Your Ref: OWPC14383
Our Ref: A/87/17/HH 08-05-2017
Please ask for:
Mark Jones

Single storey rear extension under pitched roof
The Old Cottage Station Road Angmering

Thank you for your internet representation made on 27th June 2017 which has been recorded as '**an objection**' with the comments as follows:

PROPOSED FLOOR PLANS 1:50

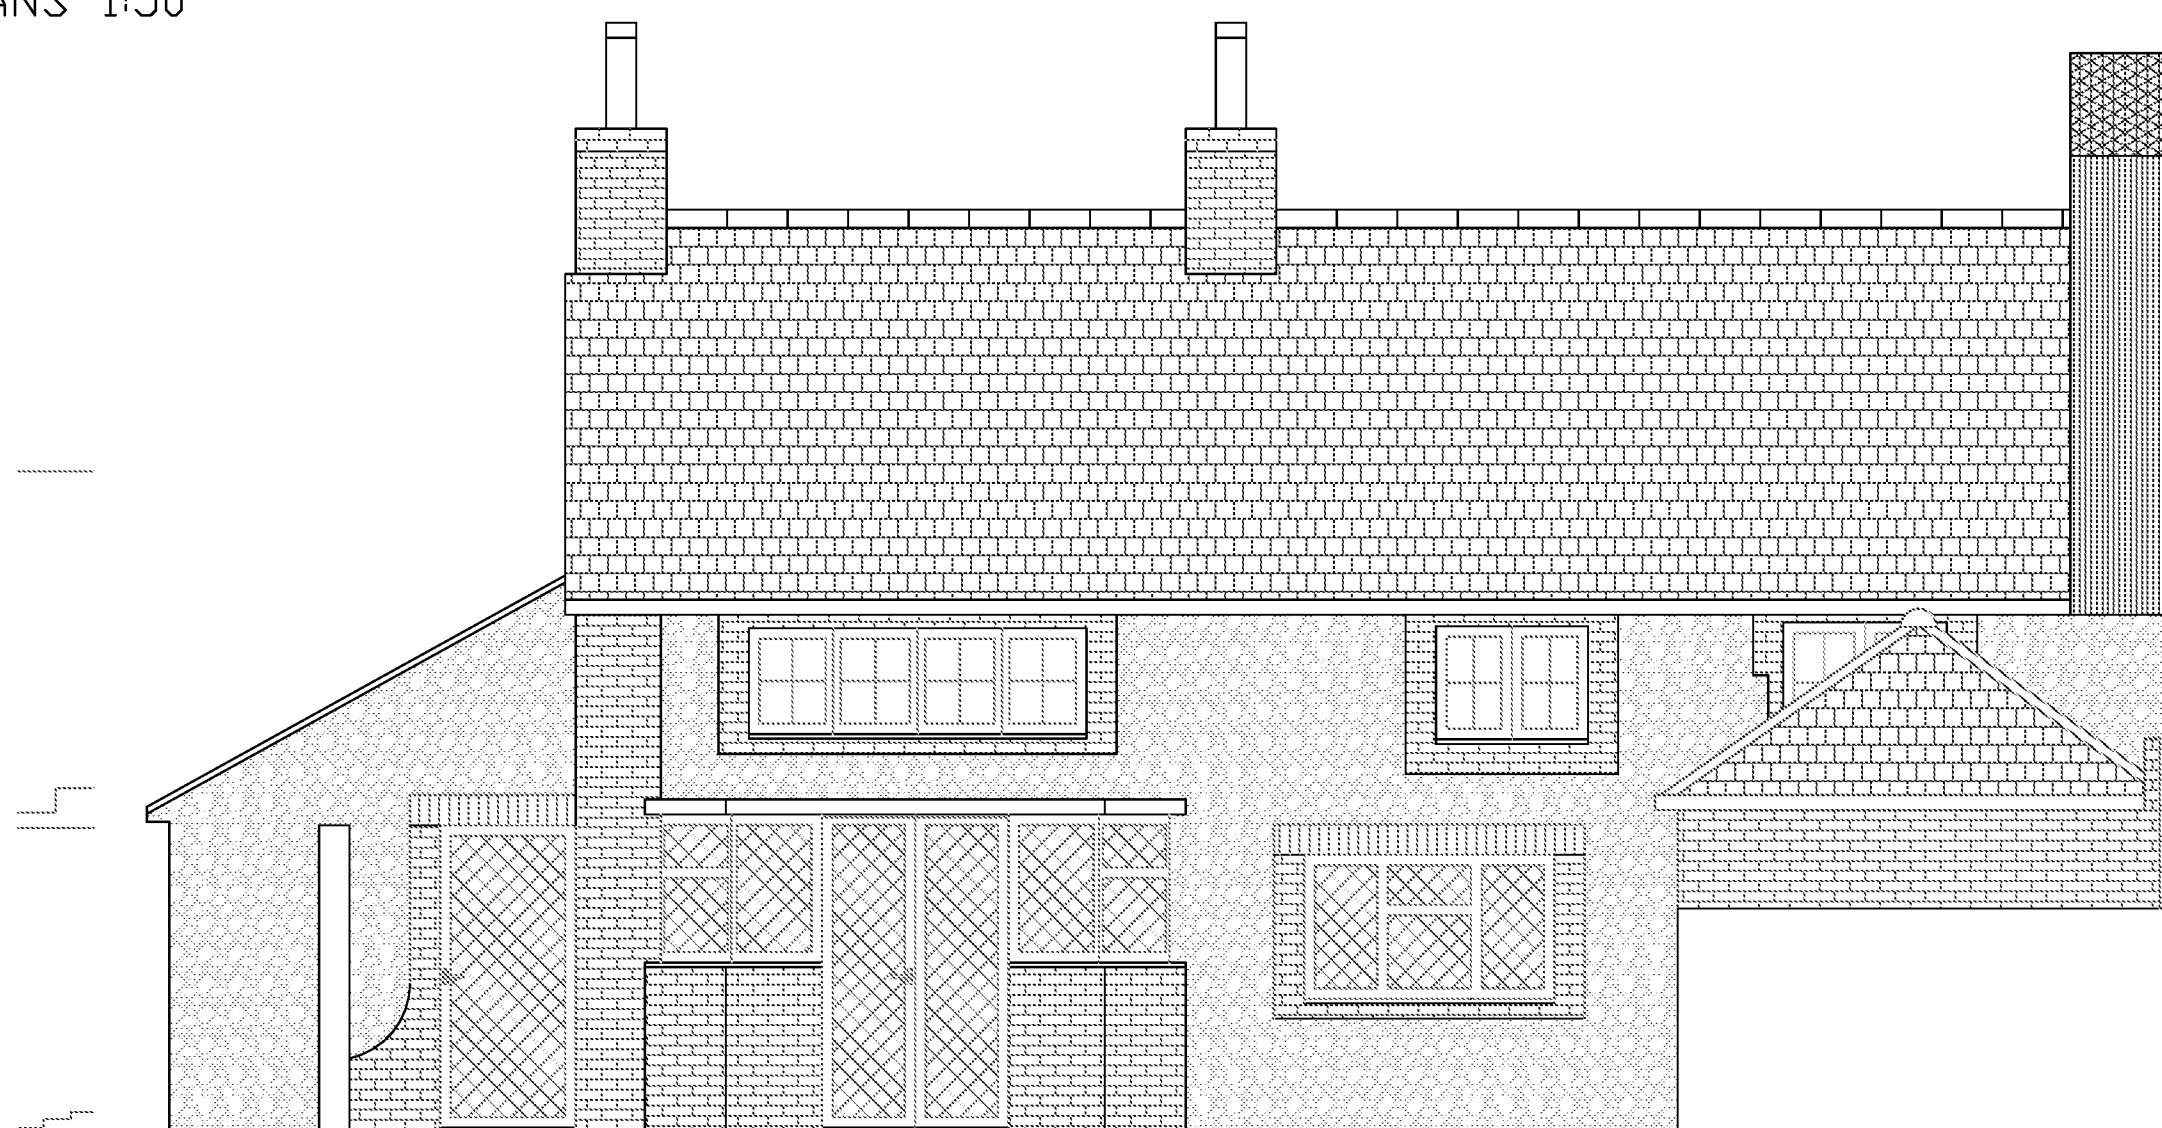
This plan appears to infringe on land currently occupied by the neighbouring property, The Old Mill House. The proposed outer wall of the breakfast room continuing the line of the existing outer wall of the kitchen would require the demolition of the existing boundary fence and the digging up of the hedge, garden and mature shrubbery of the Old Mill House. This land has been used by the owner of the Old Mill House for 38 years as part of their own fenced in garden, regardless of any line which might (?) be officially drawn on the Deeds. This gives right of possession to the Old Mill House not the Old Cottage. There needs to be a thorough investigation of the boundary question before any work is permitted, especially as the owner has recently moved to a Care Home and cannot monitor this on a daily basis.
